**From:** [REDACTED]  
**To:** [A303 Sparkford to Ilchester](#)  
**Subject:** South Somerset Bridleway Association's response to Deadline 7  
**Date:** 29 May 2019 16:35:39  
**Attachments:** [SSBA deadline response 7 May 30 2019.docx](#)

## South Somerset Bridleways Association

### Response to Deadline 7

FIGURE 2.5  
HAZLEGROVE JUNCTION UNDERBRIDGE  
GENERAL ARRANGEMENT

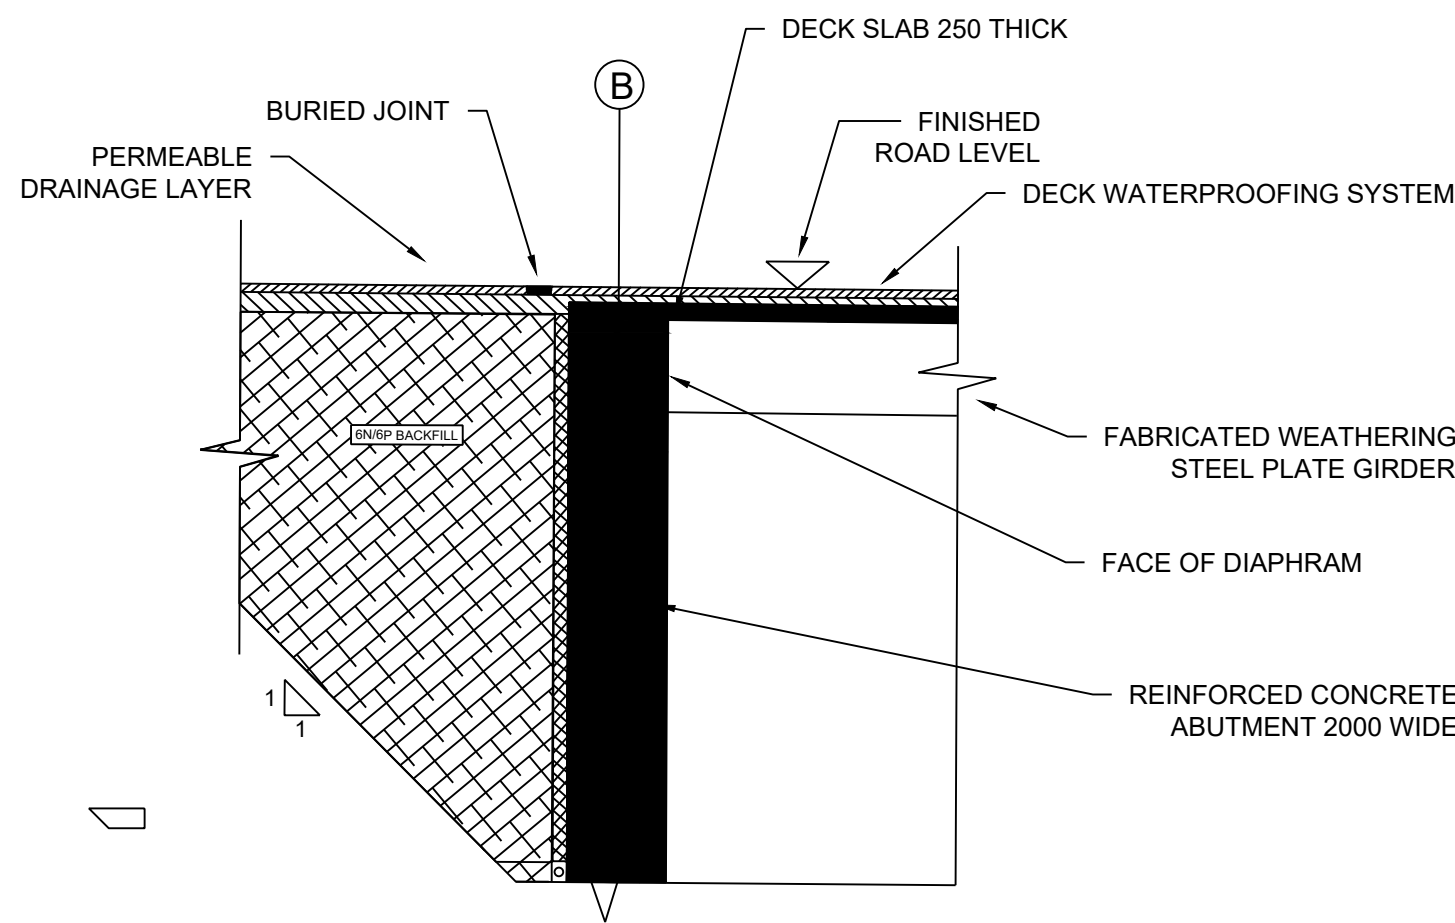
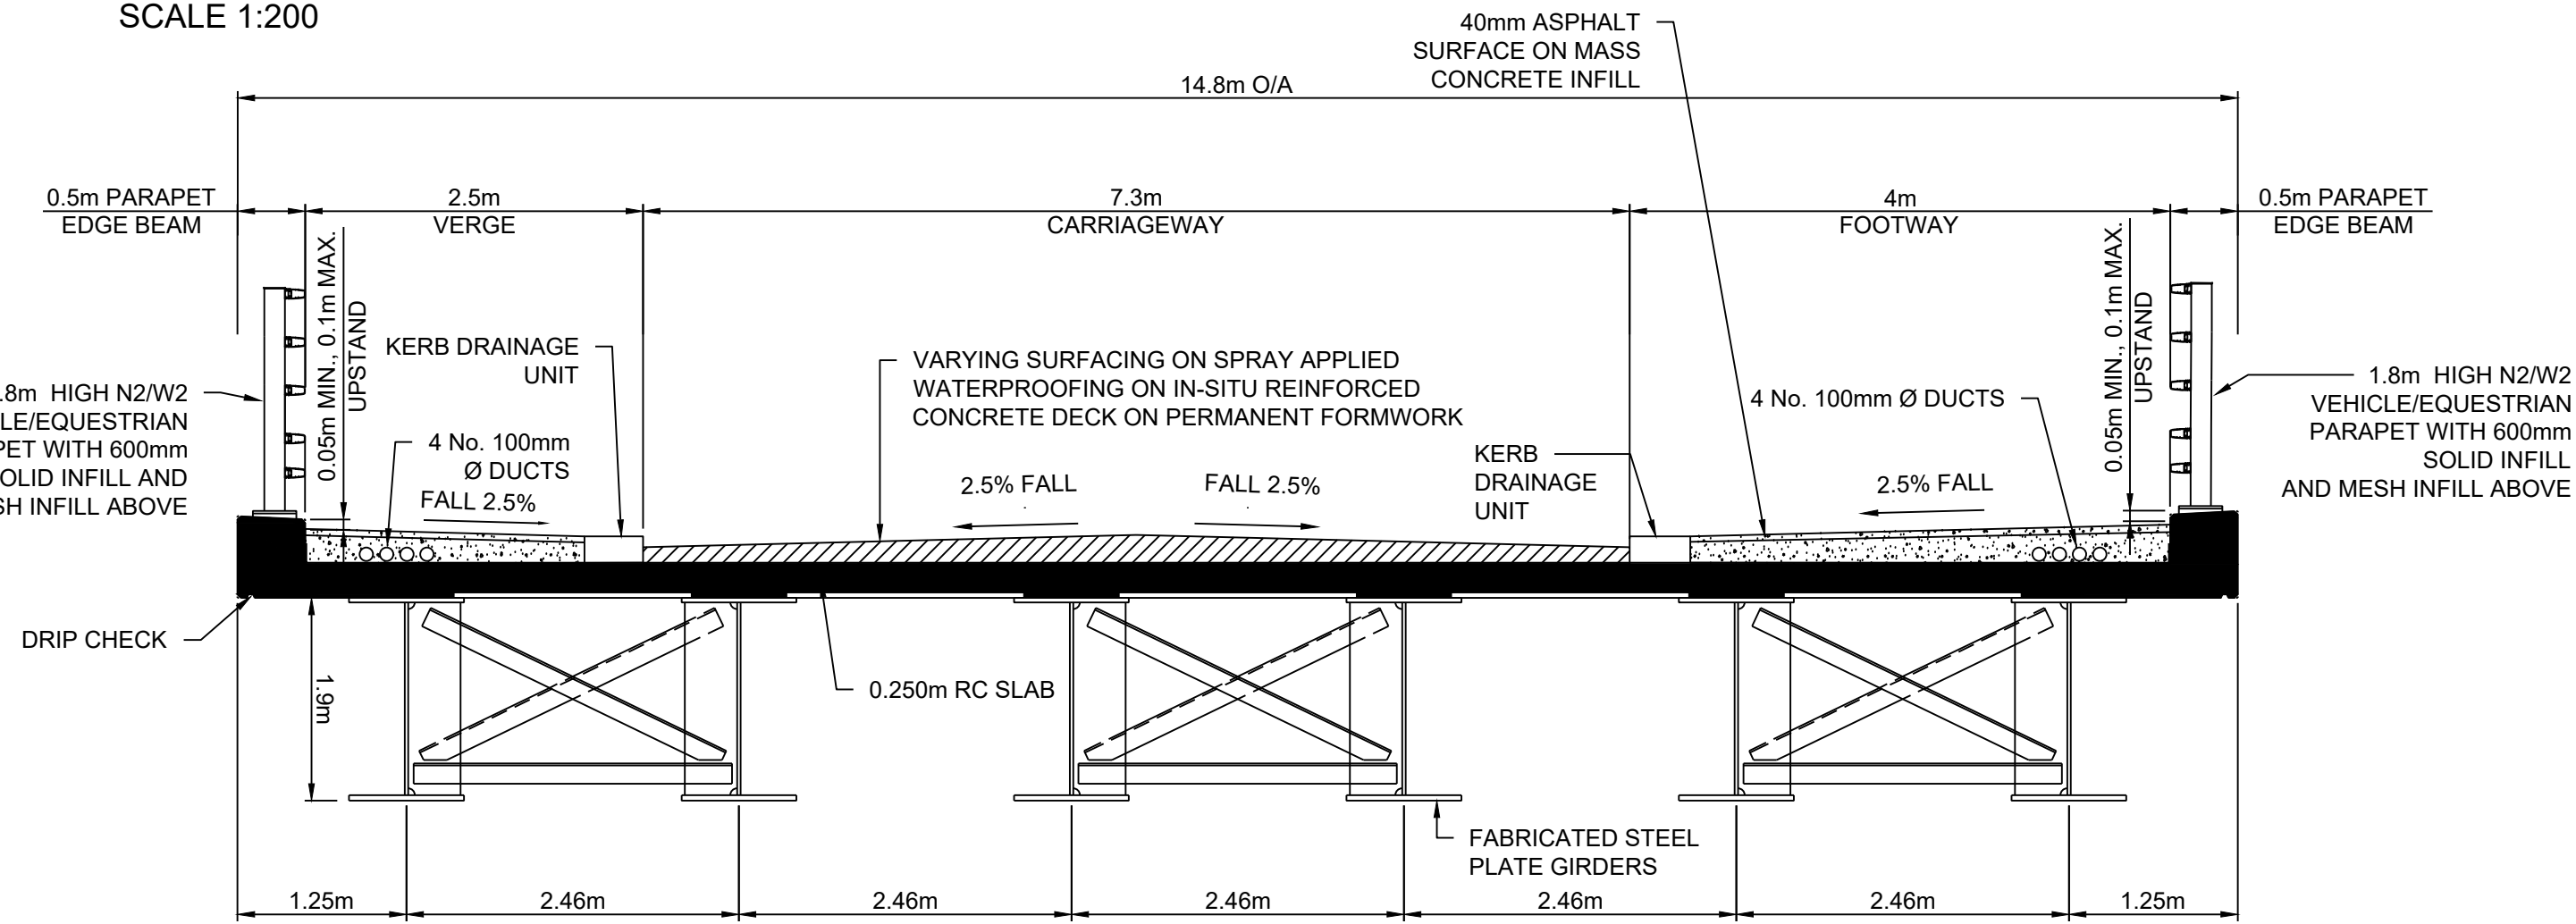
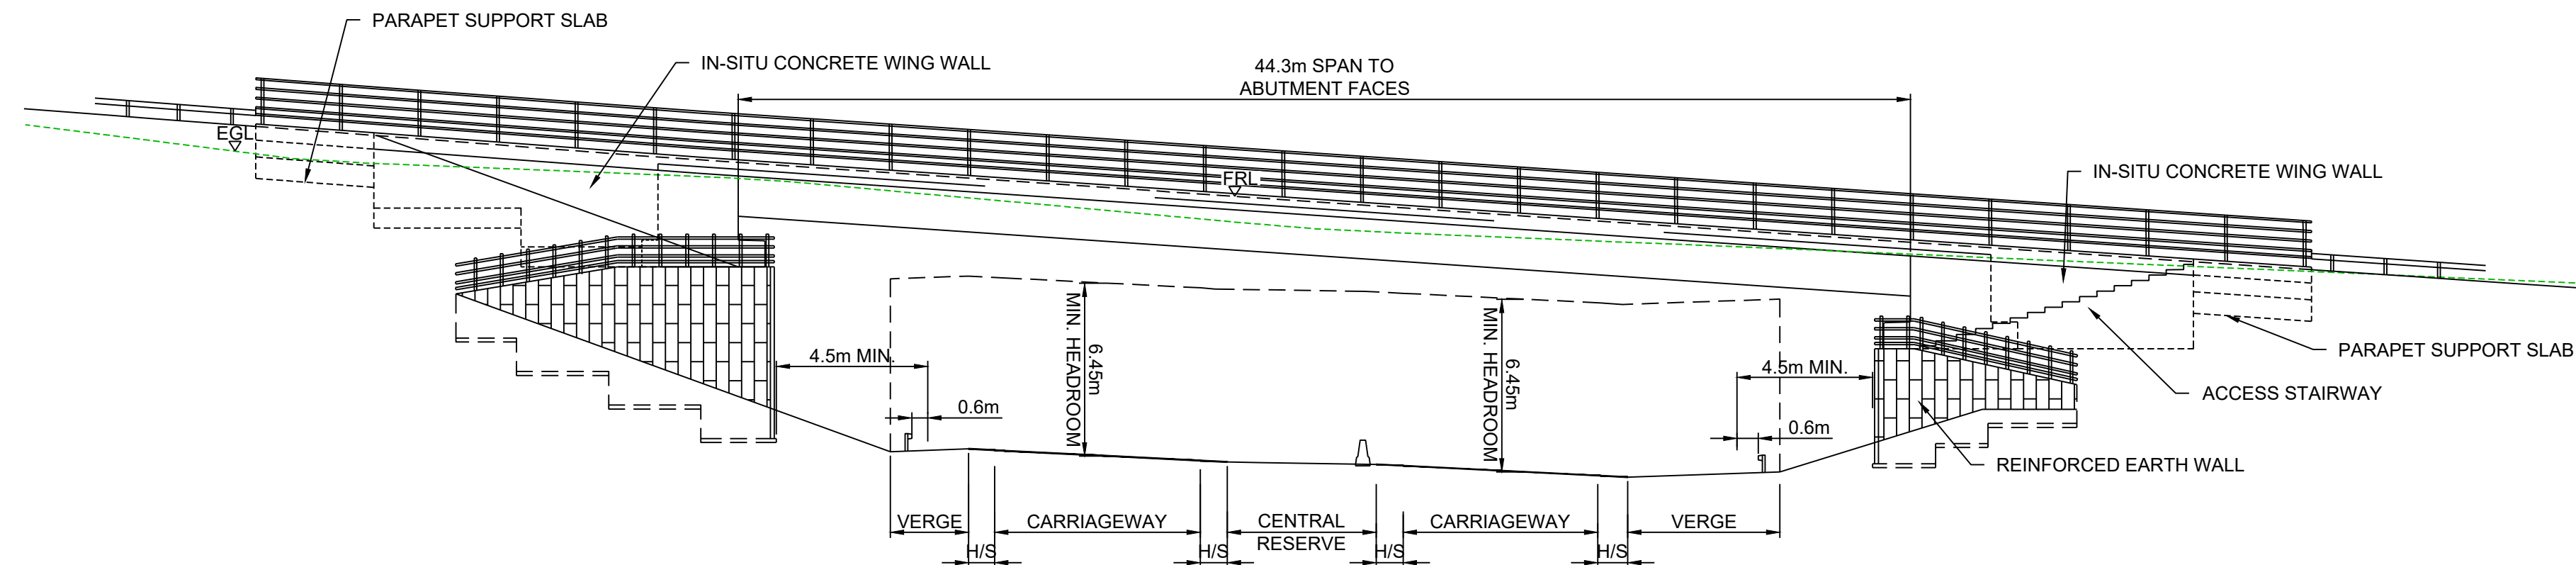
### 6.1 status of NMU rights over Steart Bridge and through the tunnel at Hazlegrove roundabout.

Elevation drawings submitted for both the Hazlegrove tunnel and Steart Hill overbridge (elevation drawings produced July 2018) exclude equestrian routes. They comprise 2.5 metre verge, 7.3 metre vehicular carriageway and a 4 metre wide footpath. The proposal states, schedule 3, part 11, that there will be bridleways dedicated alongside the carriageways on both of these crossings, (Steart Hill crossing AV to AS, and the tunnel BX to BQ to BH to BG) yet the elevation drawings show only footpaths. Assuming that these elevation drawings will be part of the tender documents, will NMU routes be built, or only footpaths? Which will be delivered, and what mitigation is there for carriage drivers?
